Recommendation Report for Lawful Development Certificate for a Proposed Use or Development

REF NO: LU/372/18/CLP

LOCATION: 23 Battin Lane
Littlehampton

PROPOSAL: Lawful development certificate for a proposed loft conversion

## Proposed Elevations

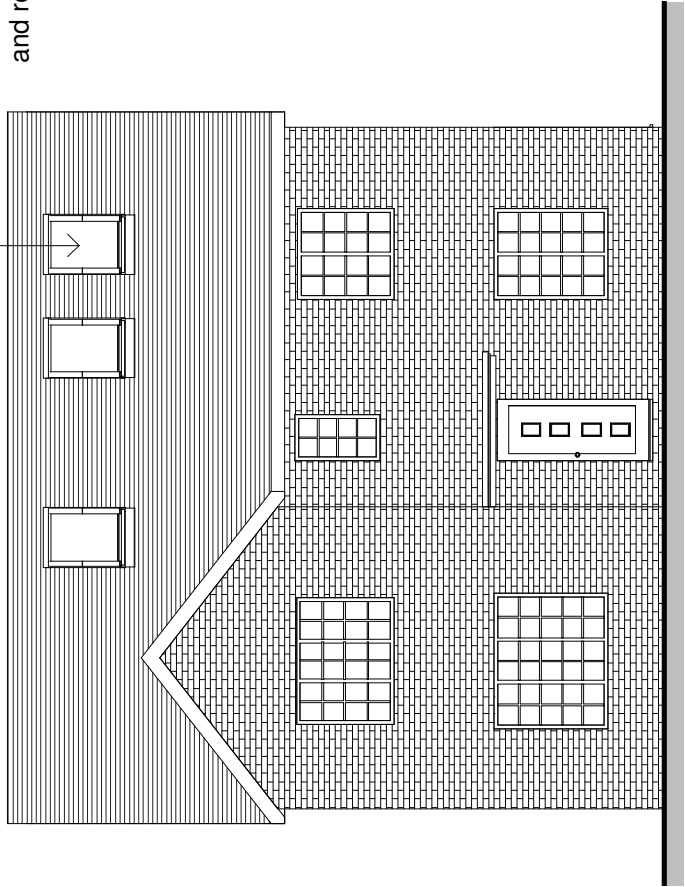
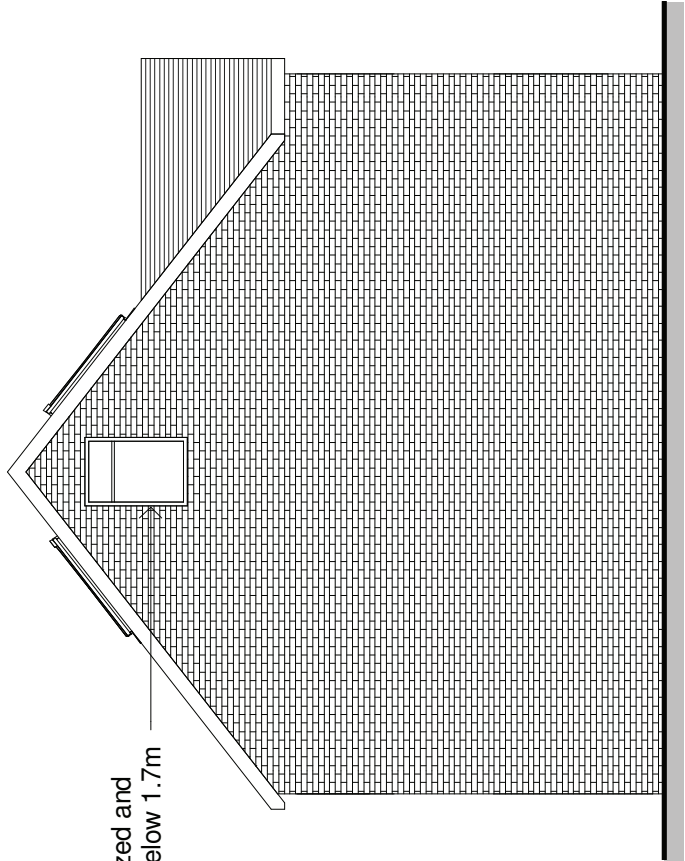
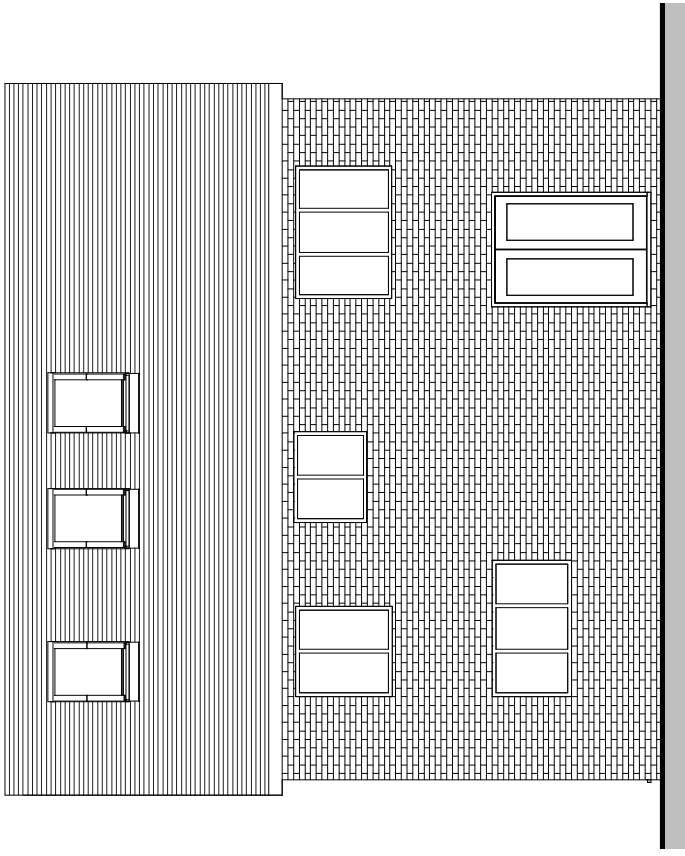
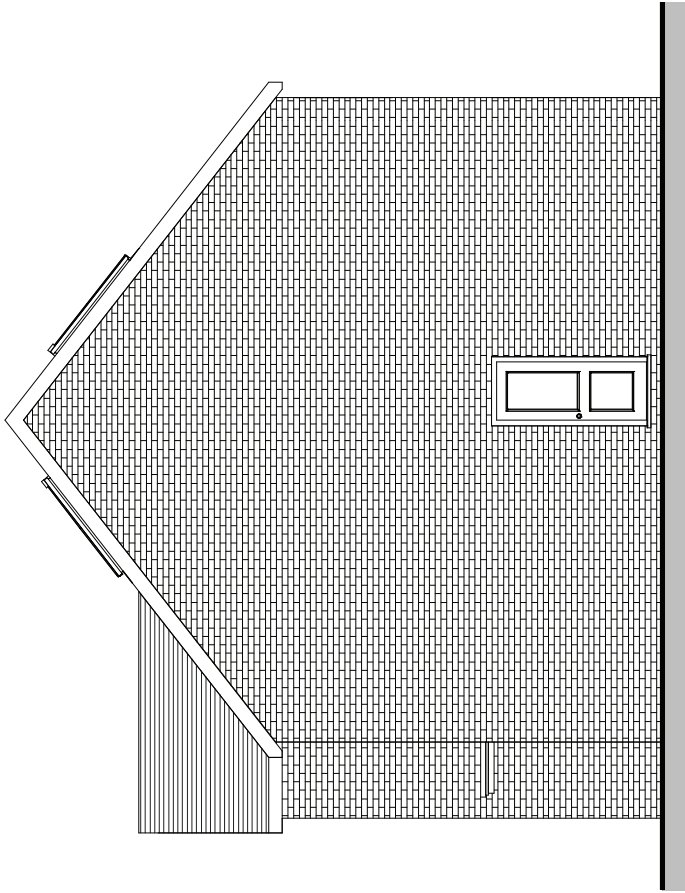
The proposed Velux windows are on the front, rear and side elevations, however the submitted plans have confirmed that the window on the side elevation will be obscured glazed and fixed close as the are below 1.7m from the floor level.
